BEFORE THE HEARING EXAMINER OF THE CITY OF MERCER ISLAND

IN RE: NOTICE OF DECISION: FILE NO.
2207-019

Case No. APL24-002

APPELLANT DANIEL GROVE'S PRE-
HEARING MEMORANDUM AND
RESPONSE TO DOROTHY STRAND
AND THE CITY OF MERCER
ISLAND'S REQUEST FOR
DISMISSAL

# FLOOR AREAS:

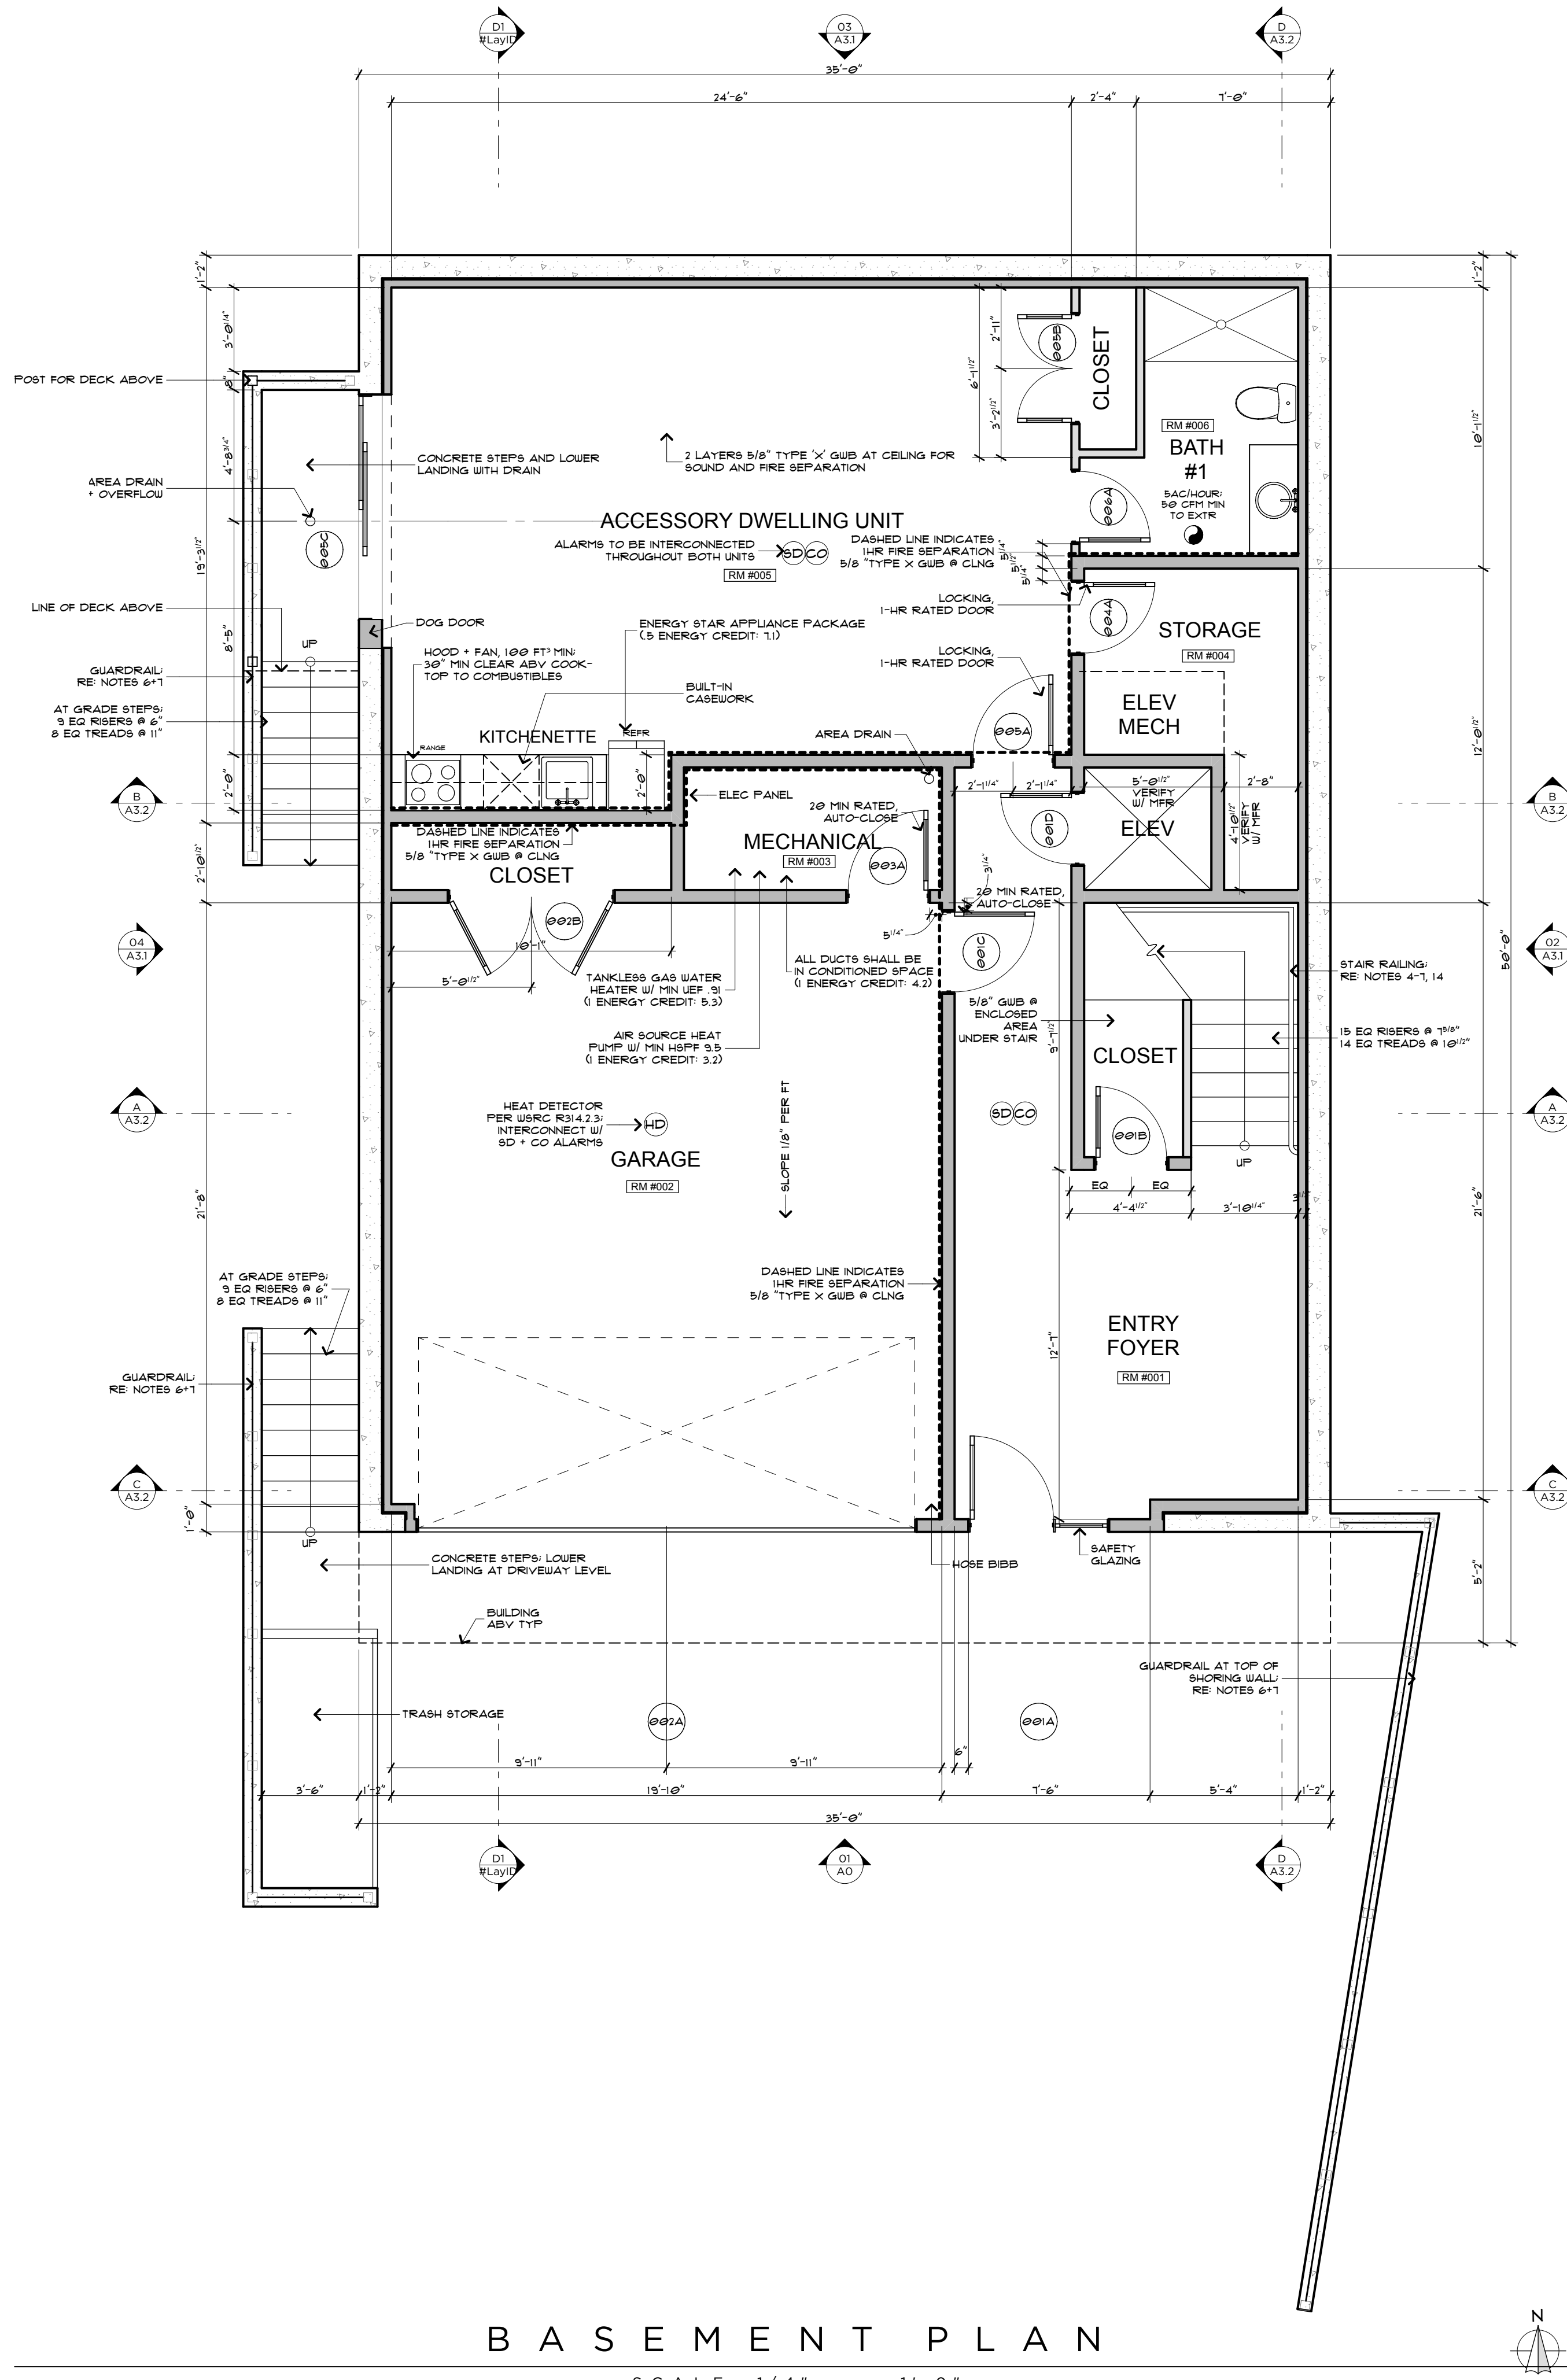
2 First, Ms. Strand misstates Mr. Grove’s analysis—at no point did Mr. Grove attempt to
3 “link” the basement exclusion area to ABE. Strand Motion at 6. Instead, Mr. Grove explained that
4 incorrect determinations of both “existing grade” and “finished grade” resulted in a larger gross
5 floor area (“GFA”) than permitted. Grove Appeal at 7. A correct GFA calculation relies on both a
6 correct calculation and correct use of “existing grade” and “finished grade.” See MICC Title 19,
7 Appendix B. Again, this is because a portion of the basement floor area (called the basement
8 exclusion area, which is used as part of the GFA calculation) can be excluded by the developer
9 depending on which is lower—the existing or finished grade. *Id.* The Final Plan Set calculated a
10 basement floor exclusion area of 937.5 square feet, Final Site Plan at A1.0, while the actual
11 basement exclusion area to be used is closer to 613 square feet. Thus, the incorrect calculations

12 and use of existing and finished grade resulted in a smaller basement floor exclusion area than is
13 used in the Final Plan Set.

14 Second, Ms. Strand incorrectly uses midpoint elevation to compute a basement wall
15 coverage of 59.37% (4’9” / 8’), rather than the “the portion of an exterior wall below existing or
16 finished grade, whichever is lower.” This is a difference of 21.36% (59.37% minus 38.01%). This
17 error alone results in 98 square feet being impermissibly added to the allowable gross floor area.
